From: Simon Davis
Sent: 30 August 2019 14:13
To: 'drew Jones' [REDACTED]
Subject: Y/53/19/NMA - North Barn, Hoe Lane

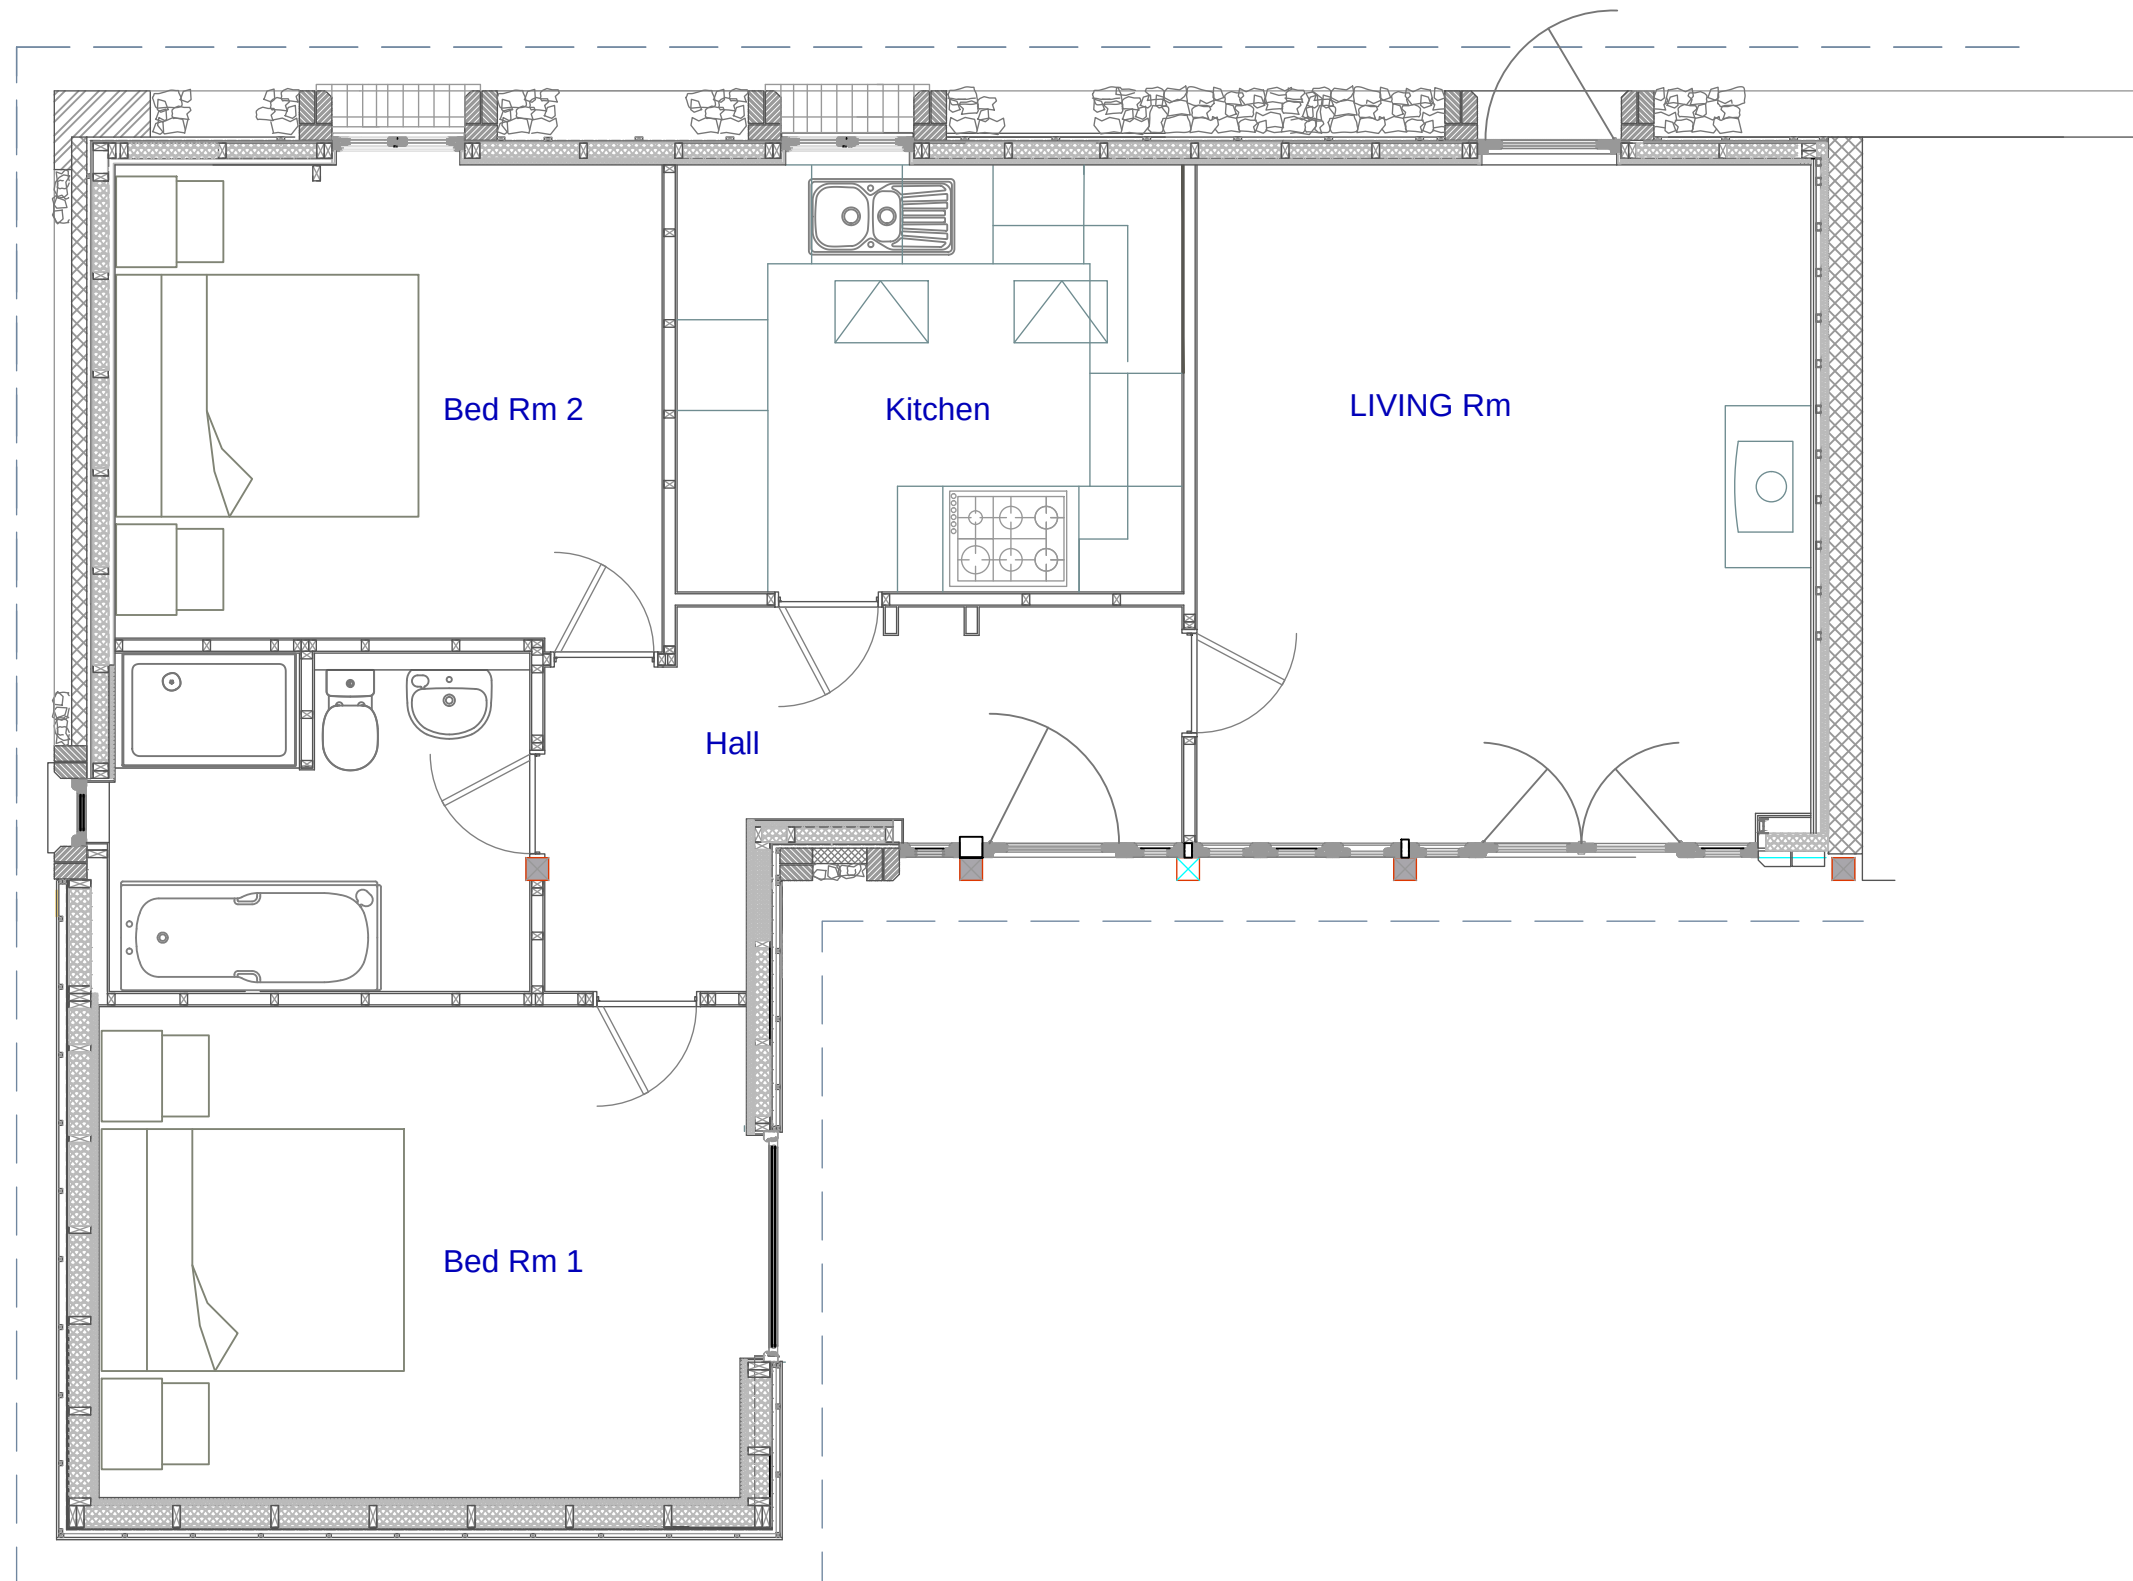
I have today discussed this matter with our Conservation Officer. He does not object to the use of timber boarding or the setting of the windows/doors behind the existing timber posts. However, he does have some concerns with the changes to the 'french door' windows on the north elevation. Although he prefers that there is now no longer a gap between the top of the door and the eaves, he does not like the fact that you can tell from looking at the windows where the opening is. He prefers the uniformity of the windows/doors approved on the original scheme. If you are able to change this then we can accept the scheme as a NMA. Please feel free to call to discuss.
